# CITY OF ALBUQUERQUE

July 2, 2018

**Re: Church Gym**  
**840 Juan Tabo NE, 87123**  
**30-Day Temporary Certificate of Occupancy- Transportation Development**  
**Transportation Development Final Inspection**  
Engineer's/Architect's Stamp dated 9-08-17 (K22D035C)  
Certification dated 06-25-18

3 ACCESSIBLE PARKING SIGN
NOT TO SCALE

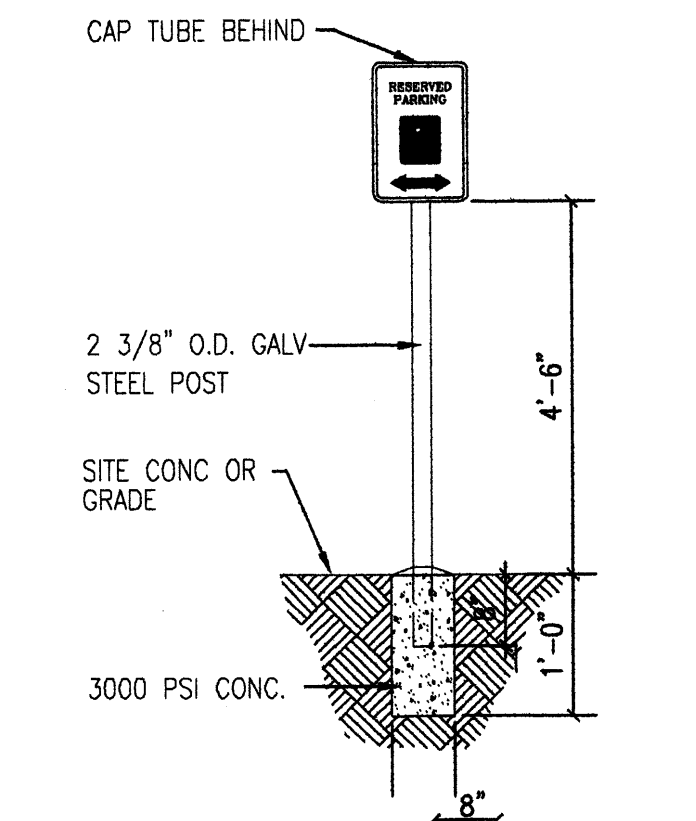
1. Please add correct ADA sign. The ADA accessible parking sign must have the required language per 66-7-352.4C NMSA 1978 **"Violators Are Subject to a Fine and/or Towing."** Please call out detail and location of HC signs.
2. Missing Directional Signage in rear of Building please add.
